**From:**   
**Sent:** 21 January 2015 12:45  
**To:** 'Michael Knappett'  
**Subject:** RE: Land adjoining Sunnyside, Westergate Street, Westergate - AL/73/14/PL

Drawing Title:
 Site Layout

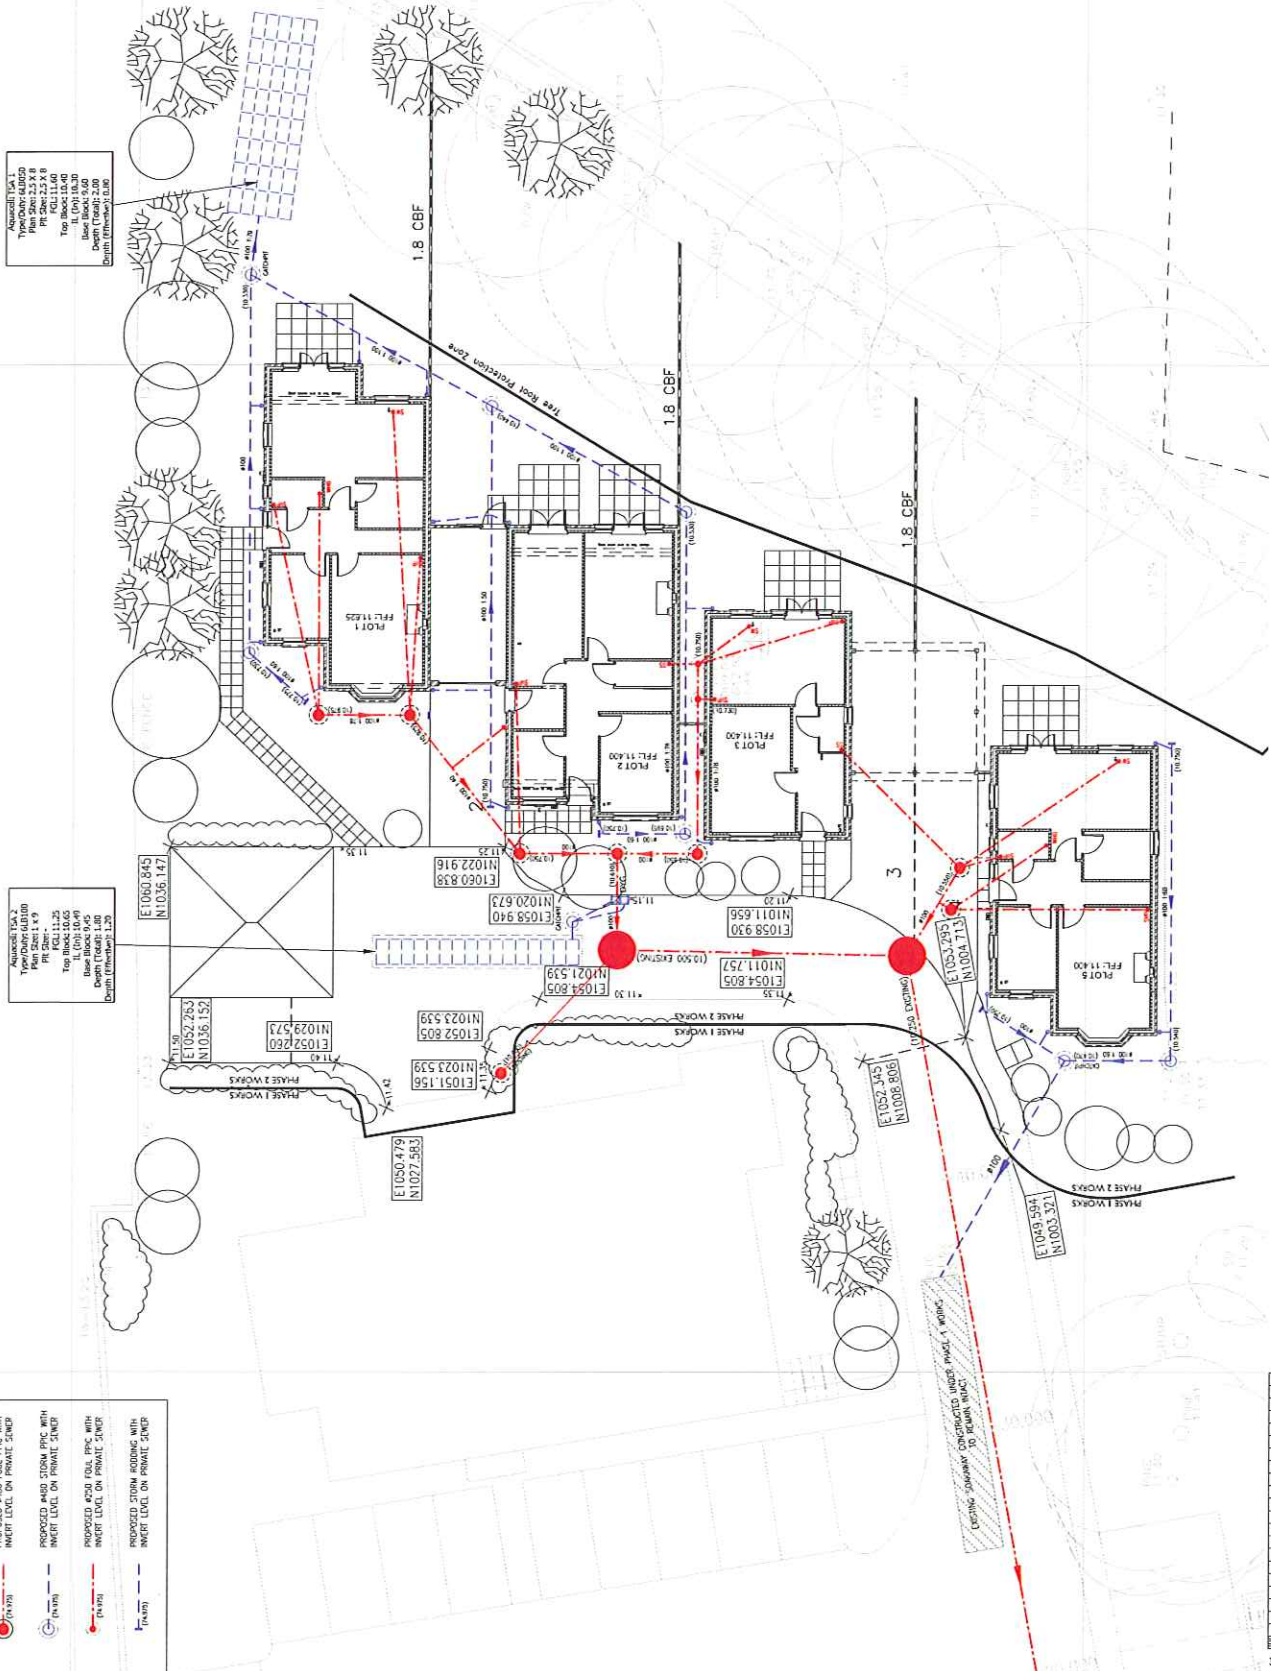
I have just written the report up. However, in doing so, I do not consider that I am able to recommend approval. I still have concerns with the external space despite your amendments. Our Policy (D DM3) does not allow for front and side areas to be used within the total private space and I do not consider that the front garden will be private.

I also have an issue with the amount of internal space. I believe I may have previously indicated that this was ok but on looking back, I realise that I made a mistake calculating the total internal space in that I never divided the total for the building by 2 to get the space for each dwelling. I consider that it might be possible to remove the objection on the grounds of Policy D DM2 by reducing the number of bedrooms from 3 to 2 (as the internal requirement would then be 83m<sup>2</sup>) but a 2 bed dwelling would still require 85m<sup>2</sup> worth of private amenity space and I don't believe that this can be achieved on this plot. Accordingly, I am recommending that this application be refused.
